Sent: 17 October 2012 17:19
To: Planning
Subject: ✓ Planning application S6/2012/1775/FP - 63 The Ridgeway

Response to Planning application from Hertfordshire County Council (T and CP GDP Order 1995)

Location
63 The Ridgeway
Cuffley

Proposal
Retention of front boundary wall, railings and gates

Existing Elevation of Walls and Gates

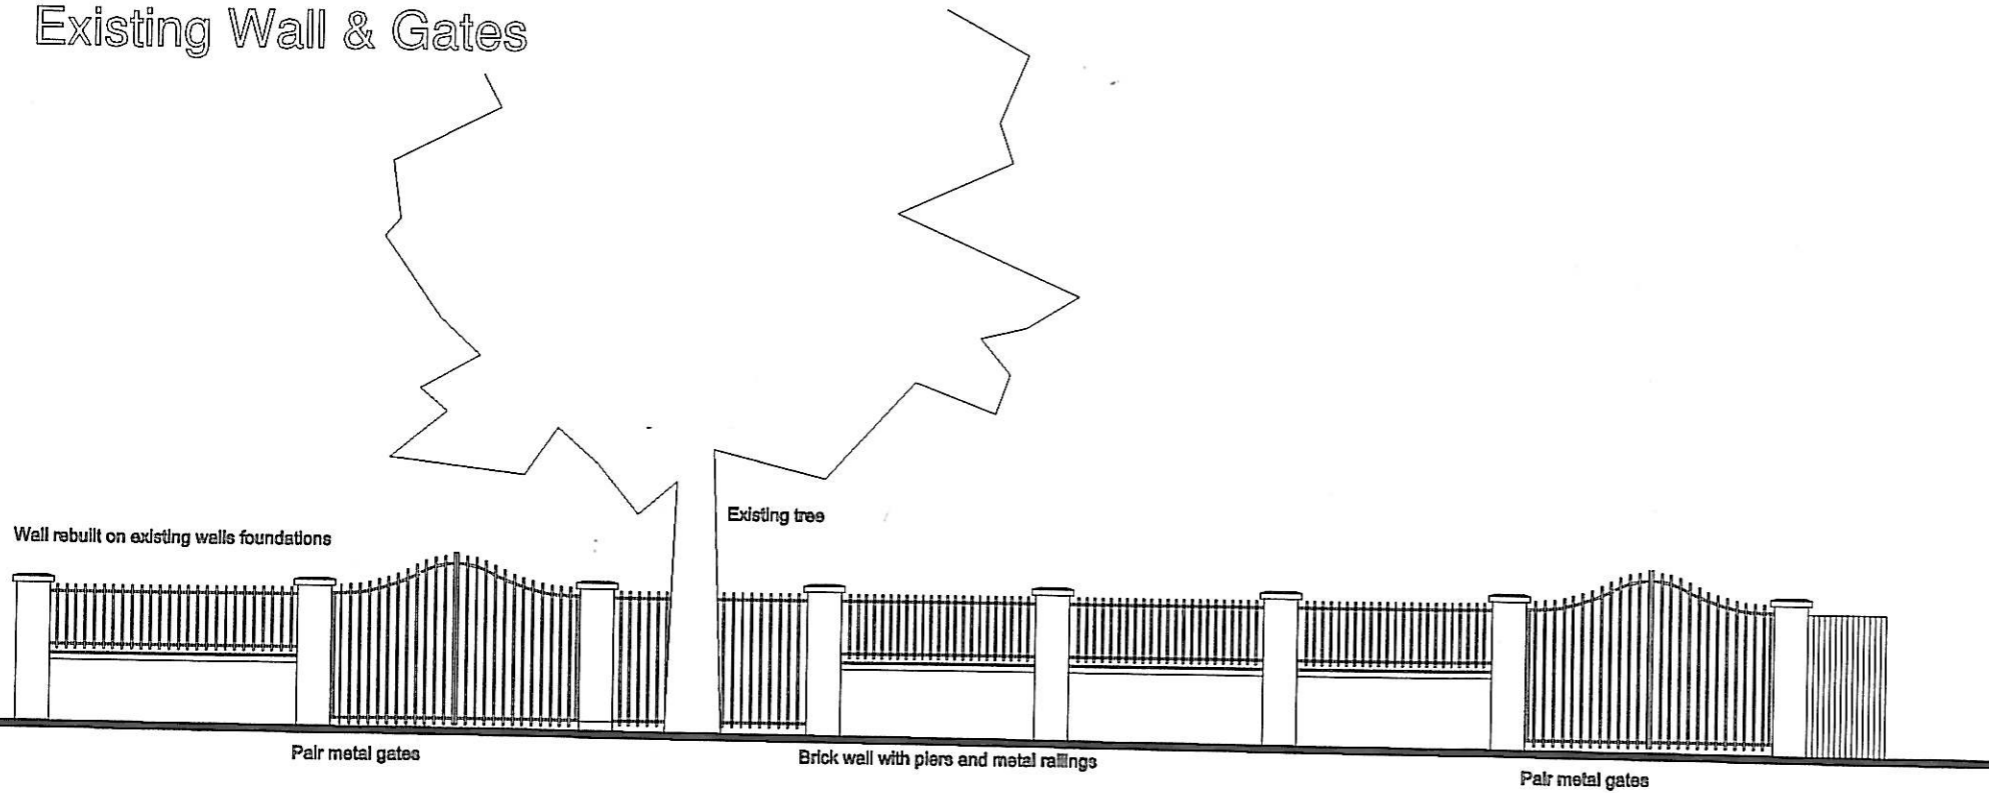
This application is for the retention of front boundary wall, railings and gates. The gates appear to be set back just over 5m from the edge of the carriageway in line with the gates to neighbouring properties. This will just allow a vehicle to wait off the carriageway whilst the gates are opened and closed. The Ridgeway is a classified road, the B157 and is designated as a secondary distributor road. Hertfordshire County Council as Highway Authority considers the proposal would not have an unreasonable impact on the safety and operation of the adjoining highways.

Decision
Notice is given under article 16 of the Town and Country Planning (Development Management Procedure) (England) Order 2010 that the Hertfordshire County Council as Highway Authority does not wish to restrict the grant of permission.
